August 7, 2012

Re: Request for Reconsideration; Cumberland County Civic Center; Site Plan Review

SHEET TITLE:	375700-SP101.DWG
WBRC CAD FILE:	375700
PROJECT NO.:	375700
SCALE:	1"=20'
PROJECT MANAGER:	MEJ
DRAWN BY:	JWB
CHECKED BY:	ARB
SHEET NO.:	CP101

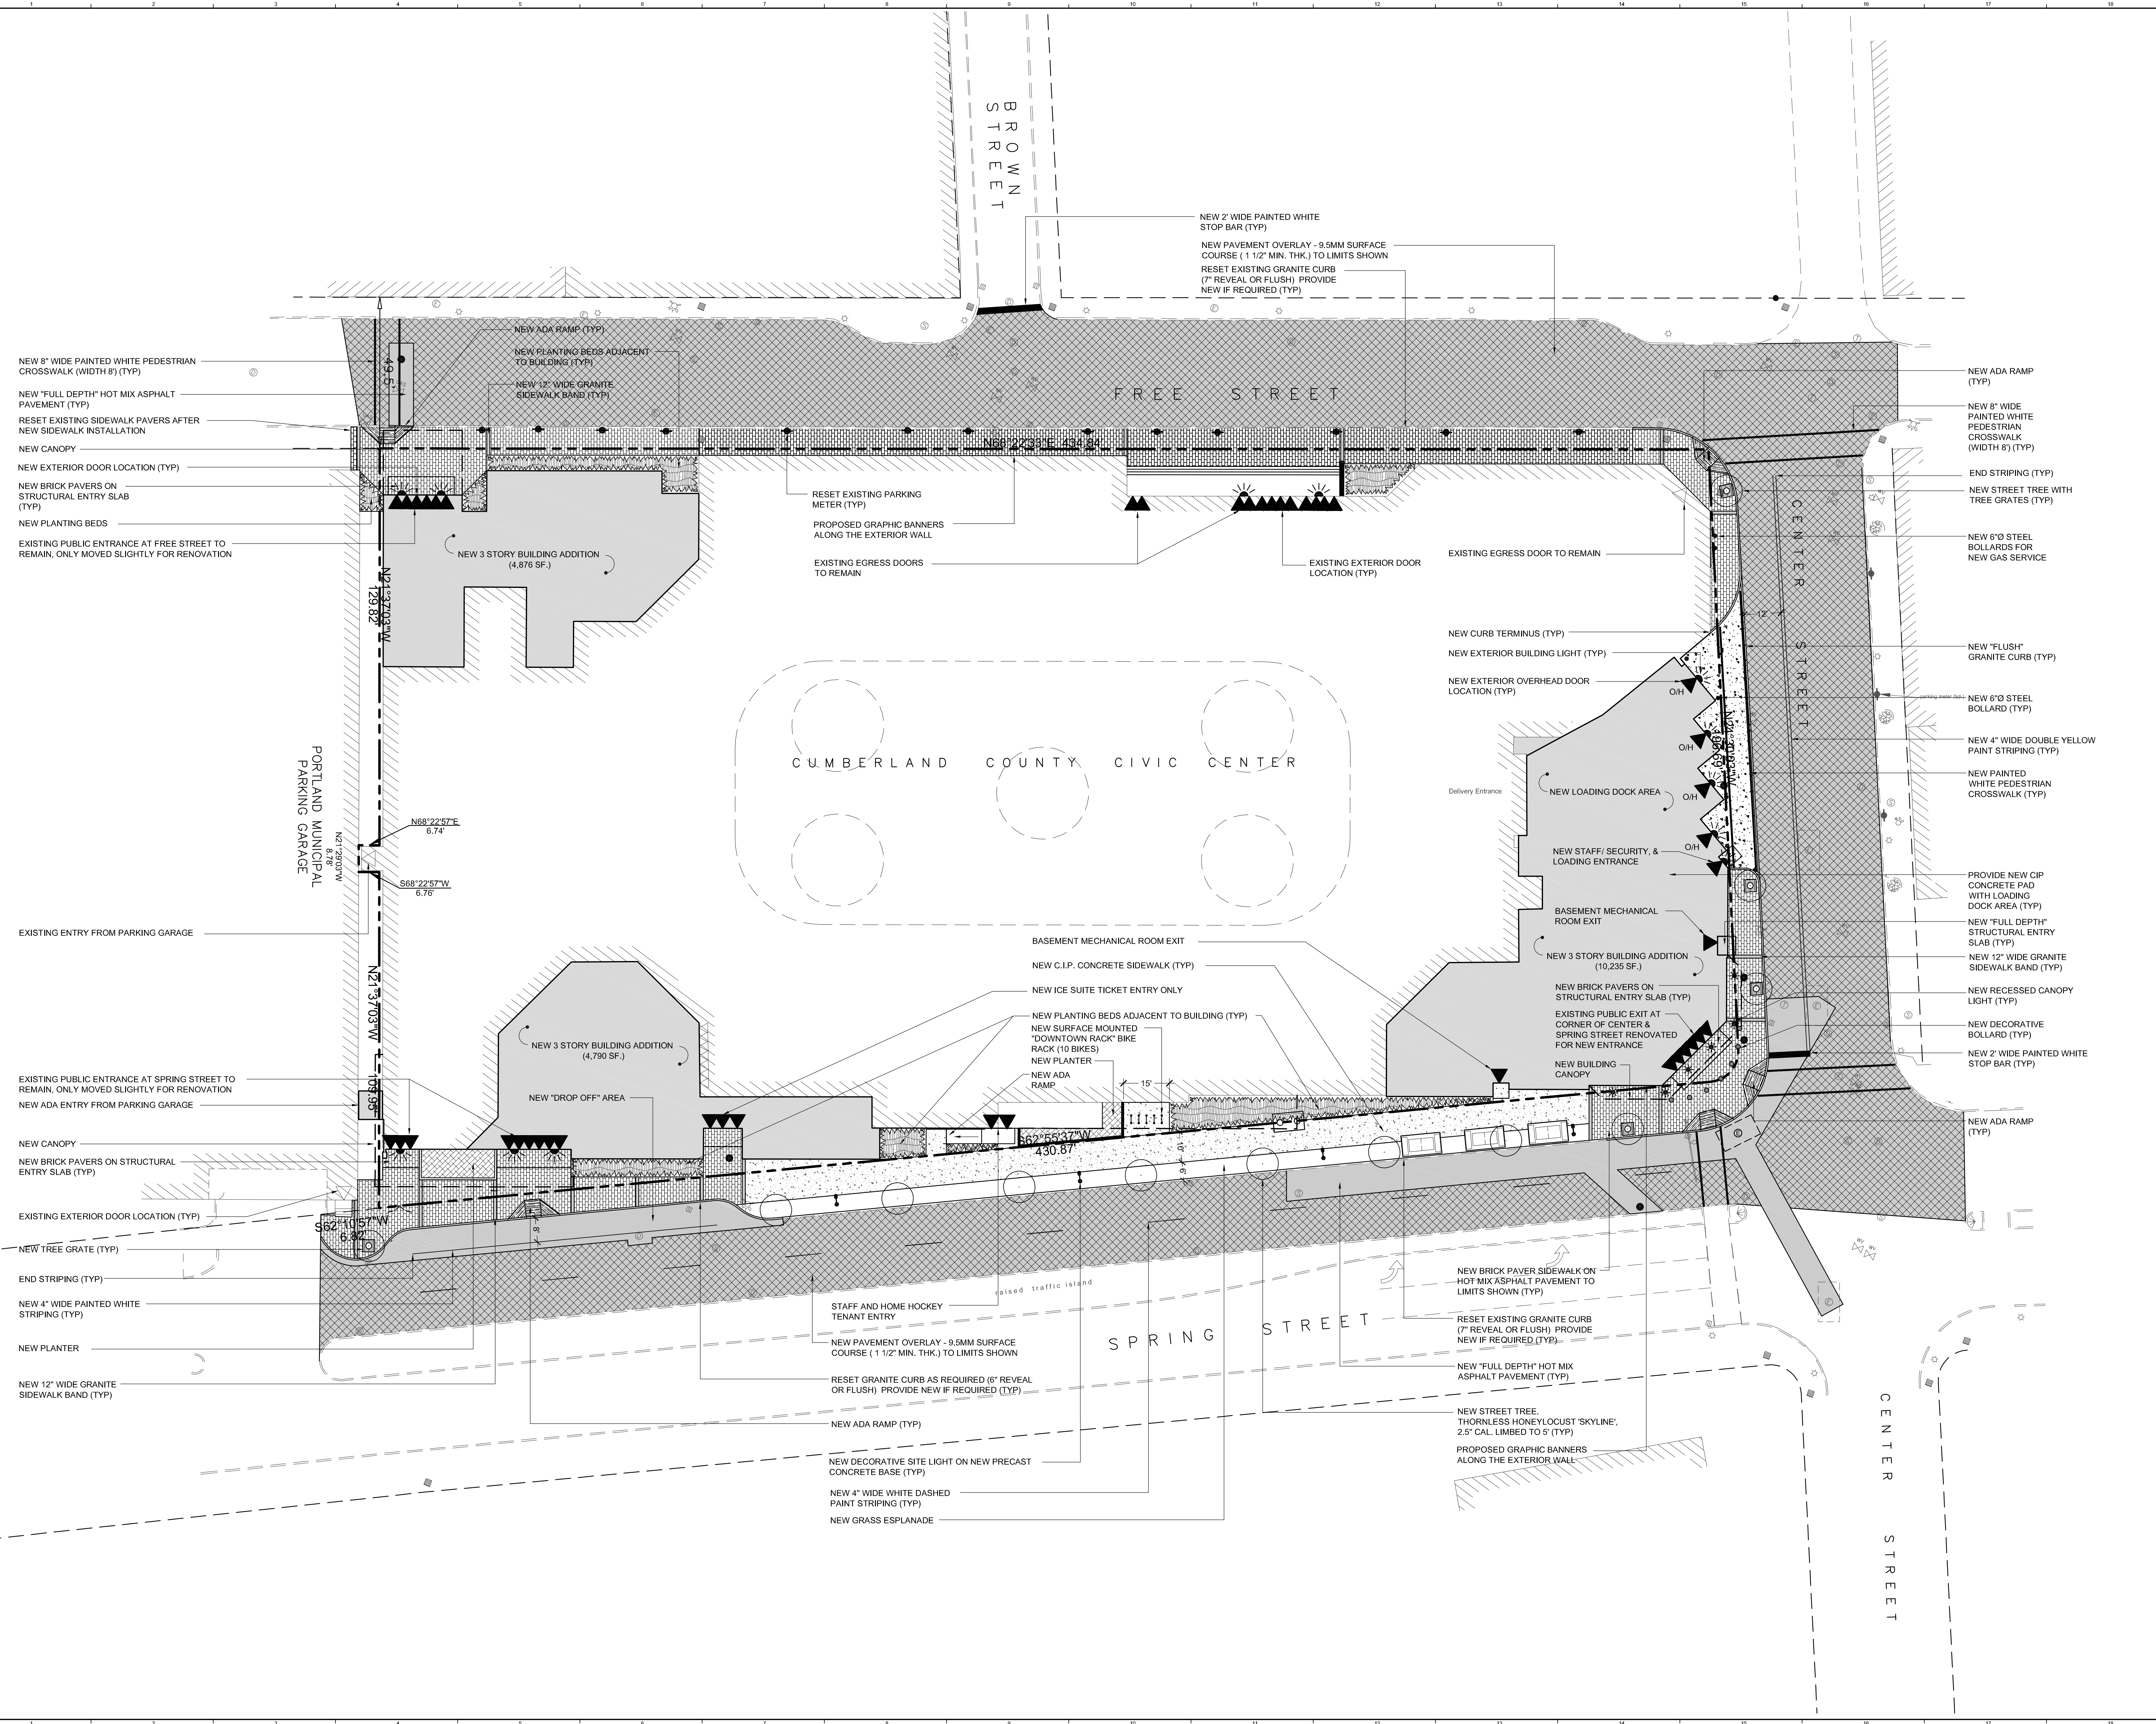
1. *Truck traffic patterns will unnecessarily tie up vehicular traffic and threaten vehicular and pedestrian safety on Center Street, Free Street and Temple Street, and will consume considerable on-street parking for an indeterminate period. The loading dock should be re-designed to avoid these problems.*

The Civic Center's proposed loading dock on Center Street has four bays that face "up-hill" at a 45 degree angle to Center Street. The single truck turning template diagram furnished to the Planning Board by the applicant shows that a 42.5' truck can (barely) drive up Center Street, across the Free Street intersection, and back into the uppermost truck bay.

PROJECT: CUMBERLAND COUNTY CIVIC CENTER RENOVATION
 SHEET TITLE: DELIVERY AT LOADING DOCK - BAY #1

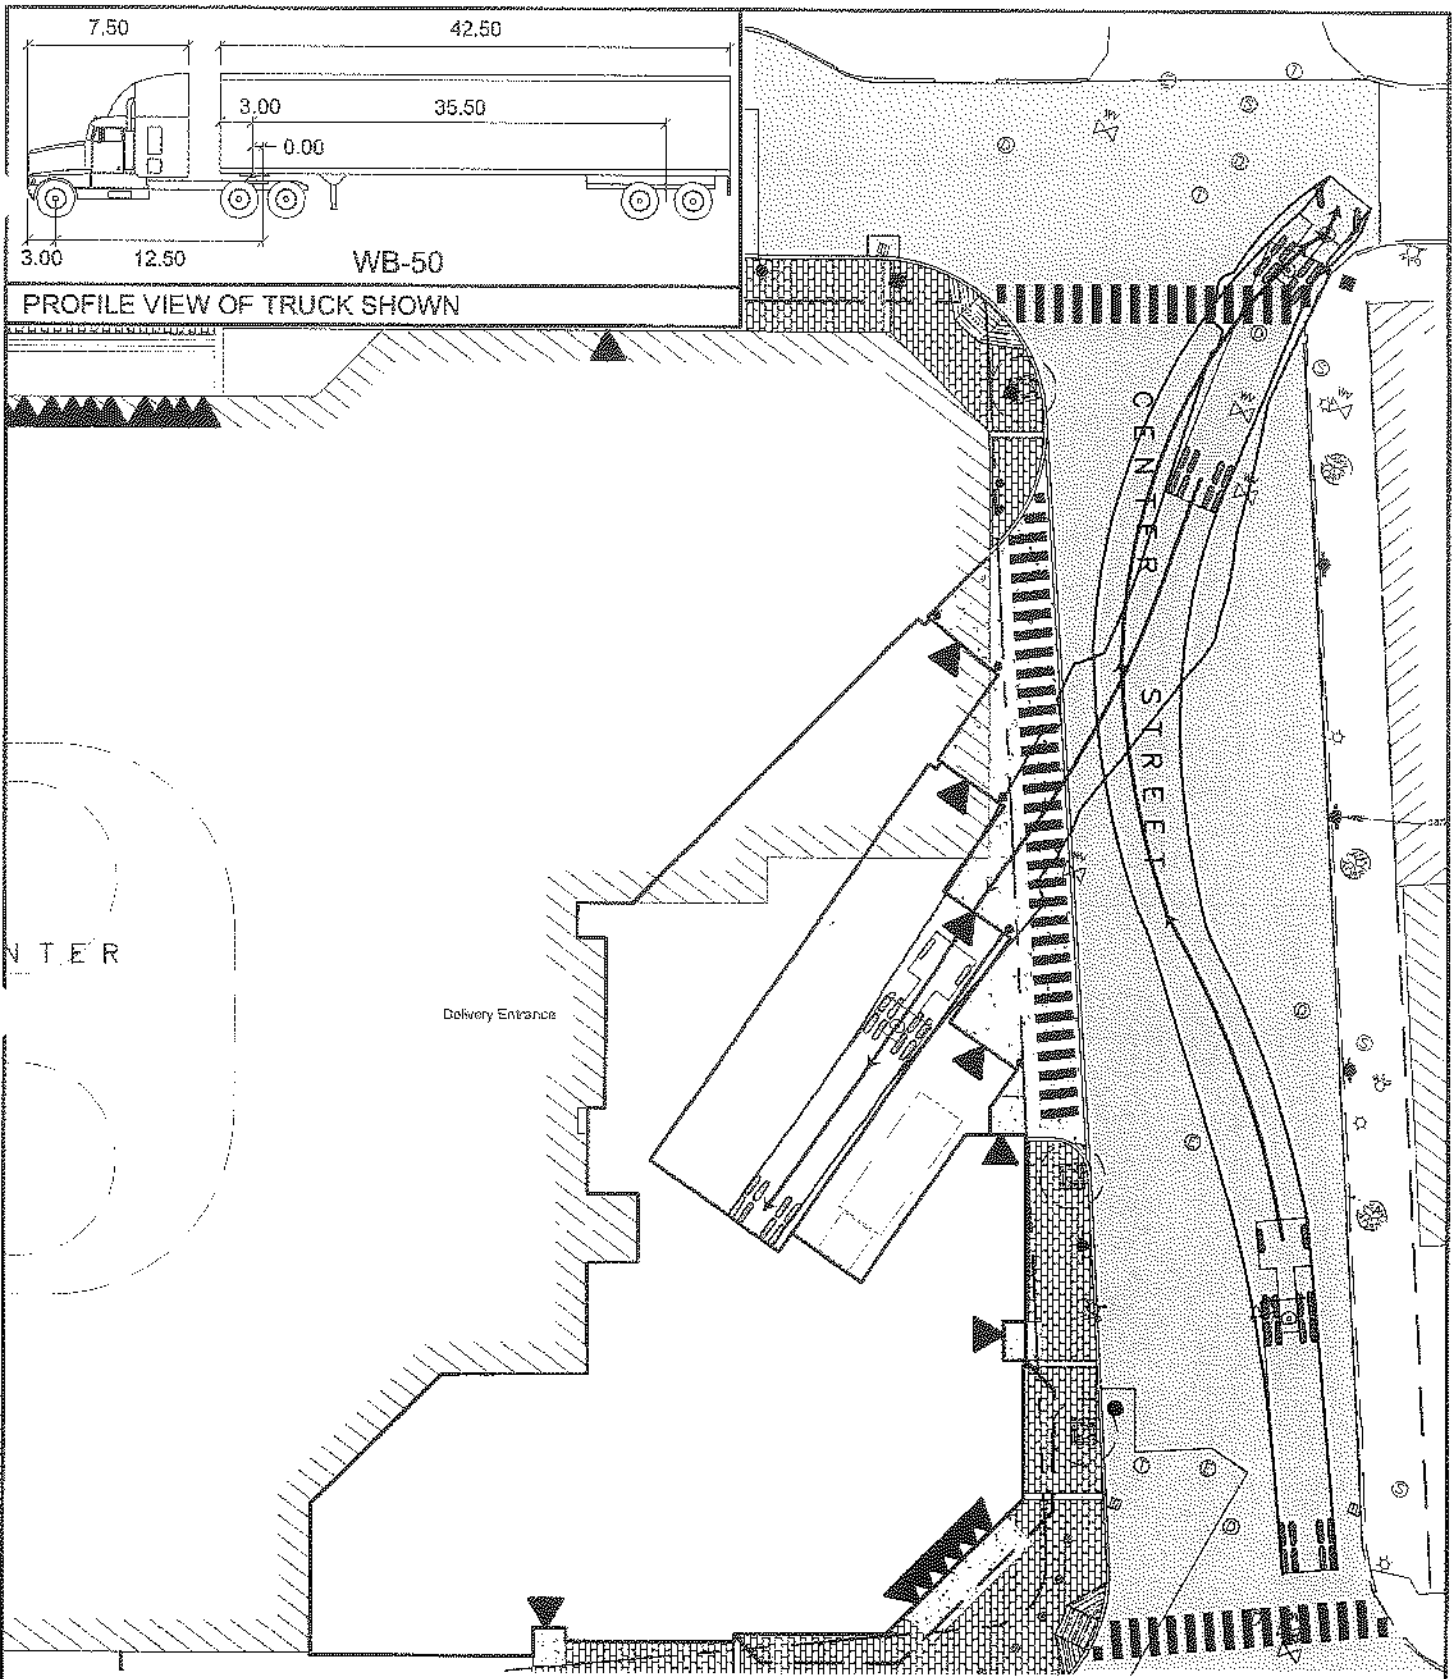
- a) The Application states that 53' trucks will use the dock shown, but no turning diagram is provided to confirm that a 53' truck can make the required maneuver into the truck dock; the 42.5' truck turning pattern which was provided shows the truck all the way across the Free Street intersection, stopping exactly at the far curb. There appears to be no more space for a bigger truck to make the same maneuver.

- b) The Application states that trucks will turn right on Free Street, but no turning diagrams whatsoever are shown for trucks making the right turn onto Free Street—neither the 42.5' truck shown entering the dock, nor the 53' trucks also stated as contemplated.

The one turning radius presented to the Planning Board, with a truck proceeding up Center Street and across the Center/Free Street intersection, then stopping to back down Center Street gives a hint of the adverse impact that will be caused by these 42.5' trucks and the bigger 53' trucks on leaving the truck bays (if they even can). As noted in the staff report, even the 42.5' truck's back and forth movement will tie up the Center/Free Street intersection and require flaggers to control vehicular traffic. According to the City, this intersection is busy with both vehicular and pedestrian traffic.
